CITY OF ALBUQUERQUE

RE: 2200 Vista Oriente
Revised Grading and Drainage Plan
Engineer's Stamp Date: 08/06/23
Hydrology File: H10D033

Based upon the information provided in your submittal received 09/05/2023, the Revised Grading & Drainage Plans **is not** approved for Building Permit and Grading Permit. The following comments need to be addressed for approval of the above referenced project:

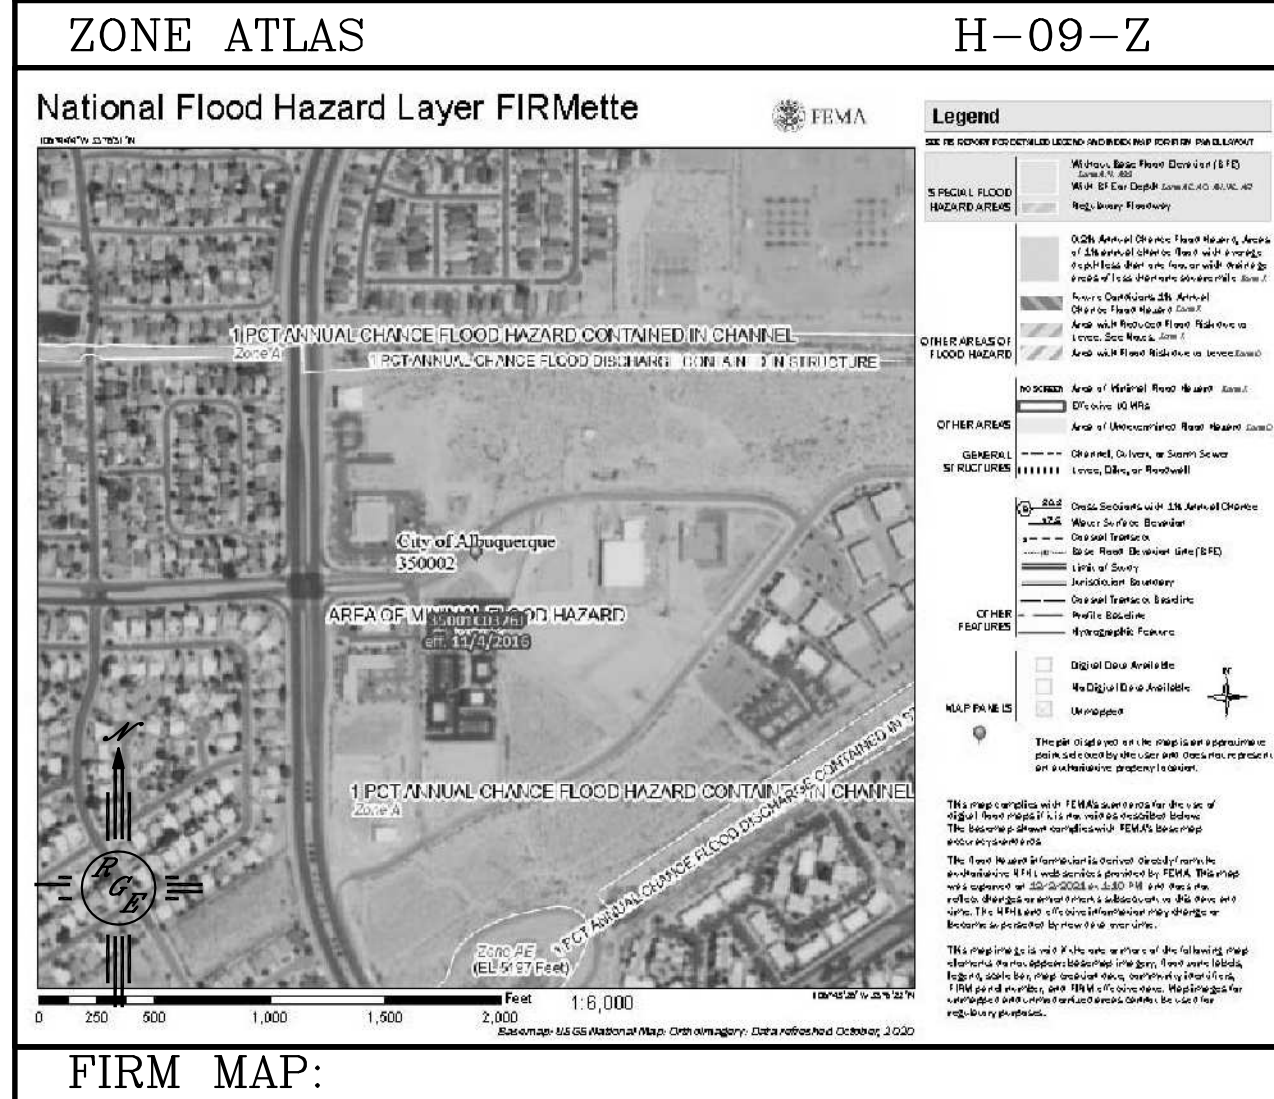
1. Please show the shared dumpster location for both of these restaurants. Also, for trash enclosures serving food service developments, trash enclosures must demonstrate control of liquids from dumpster areas per DPM by containing runoff from the dumpster area, preventing outside drainage from entering the dumpster area, and discharging to the sanitary sewer. Please show an inlet in the middle and label. "Inlet to be connected to the sanitary sewer. See Utility Plan."
